MIDDLETON-ON-SEA PARISH COUNCIL

20th October 2019

Re: Planning Application M/80/19/PL–Former Poultry Farm Land West of Yapton Road – demolition of the existing structures and redevelopment to provide a new 66 bedroom care home (Use Class C2) arranged over two storeys together with associated access, car and cycle parking, structural landscaping and amenity space provision.

Tree Protection Plan

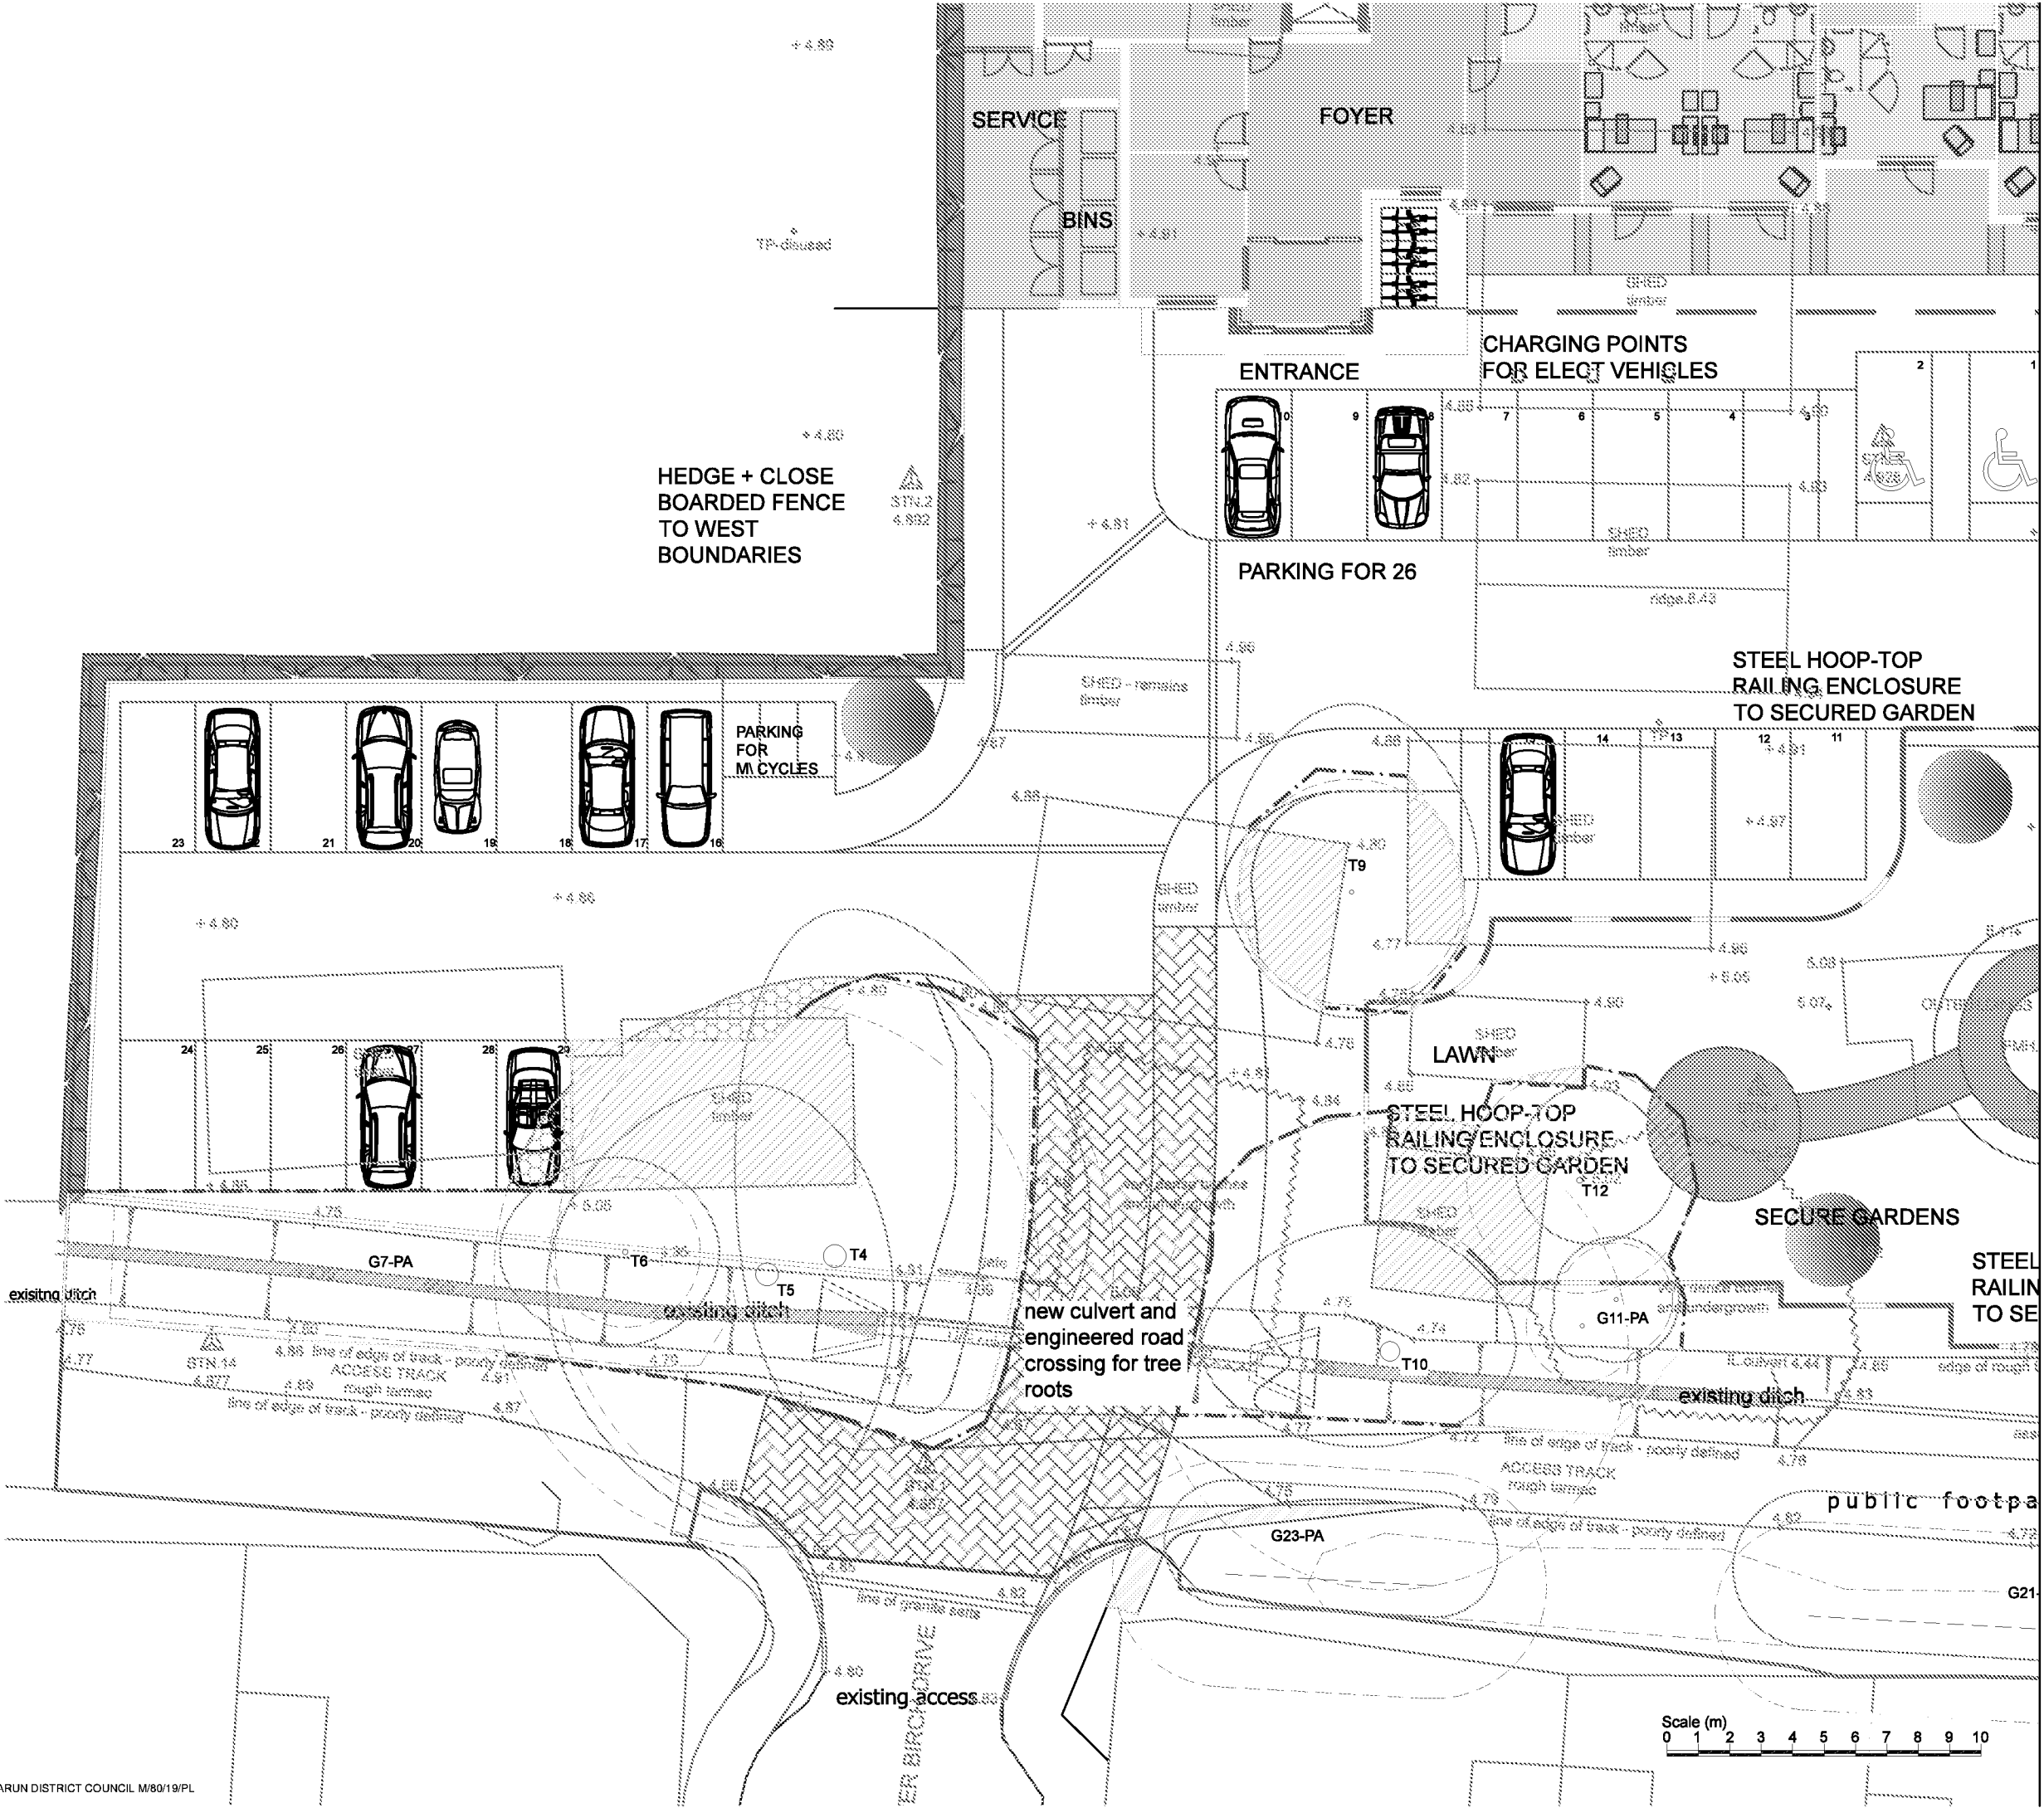
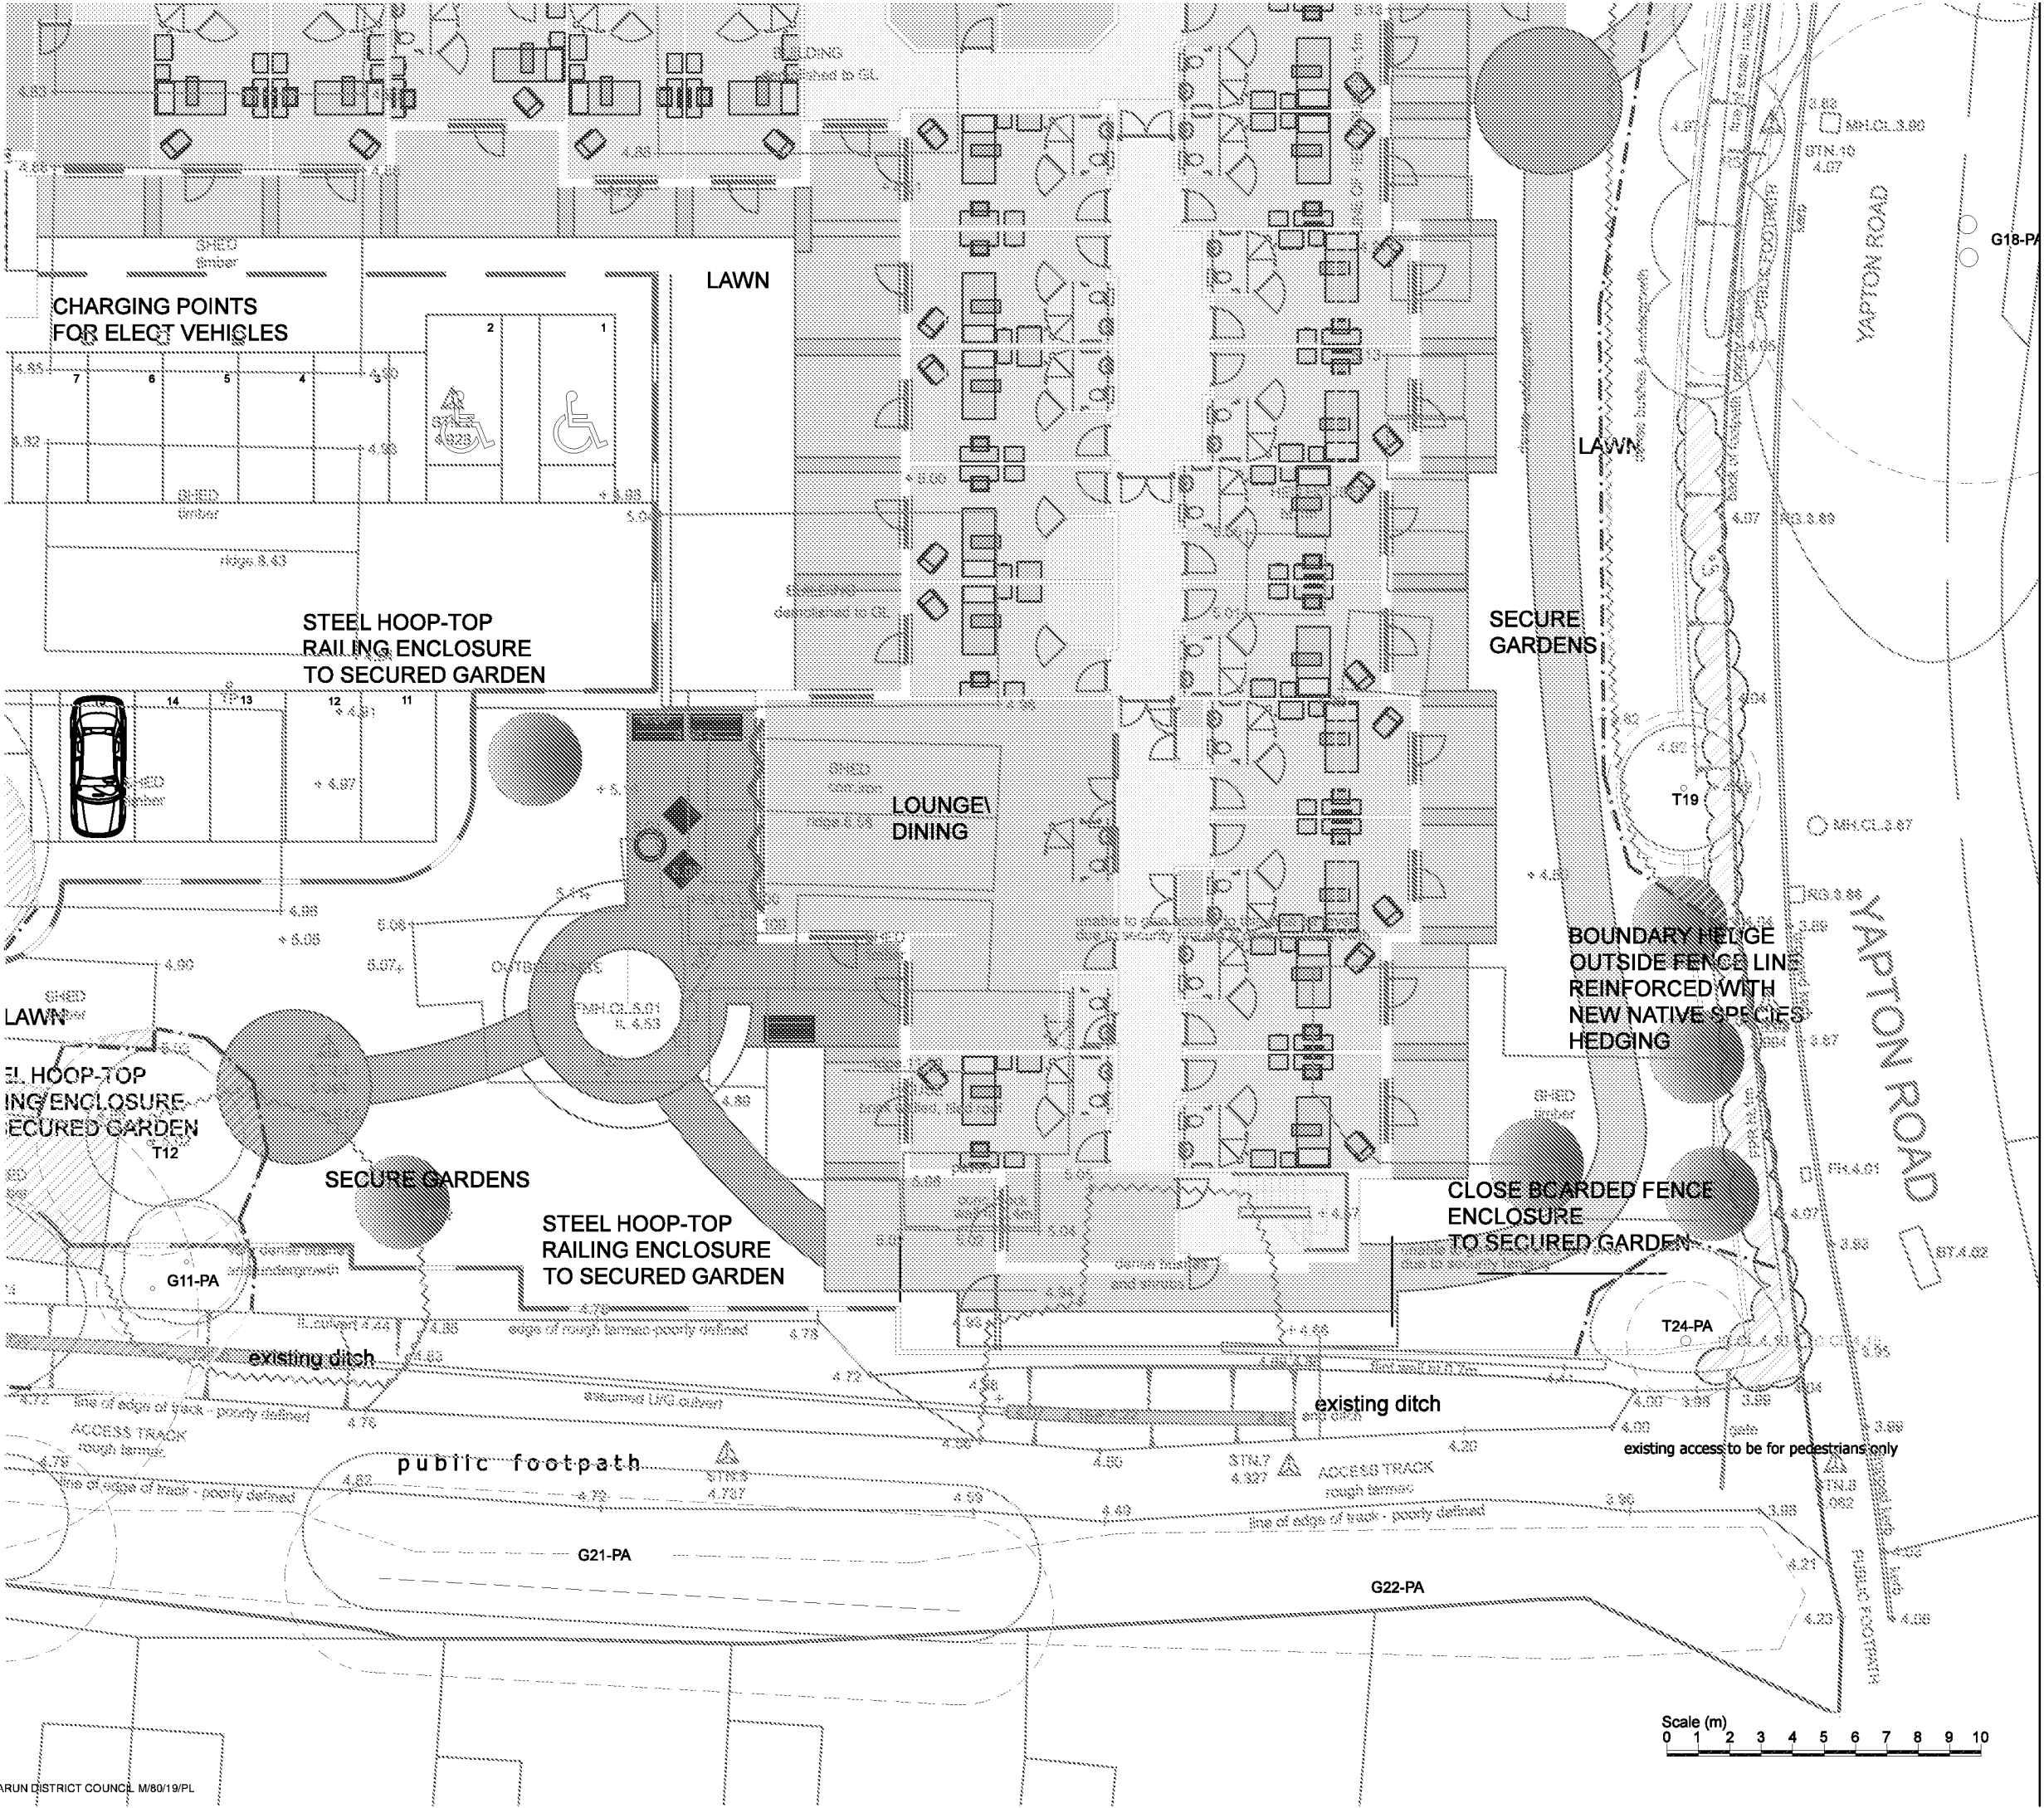
- **Loss of Trees & Trees with Tree Protecting Orders**
 - A number of trees are to be removed and there are trees on the site with protection orders which are close to the entrance of the site and these trees and especially their roots need to be protected by the building contractor. It is important that these TPO's are protected and although some evidence is shown within the reports on how this might happen we feel that more protection is needed. What are the consequences if the building contractor cuts down a TPO tree and how can we assess that the measures laid down in the report will protect the trees following construction if this planning application is approved.
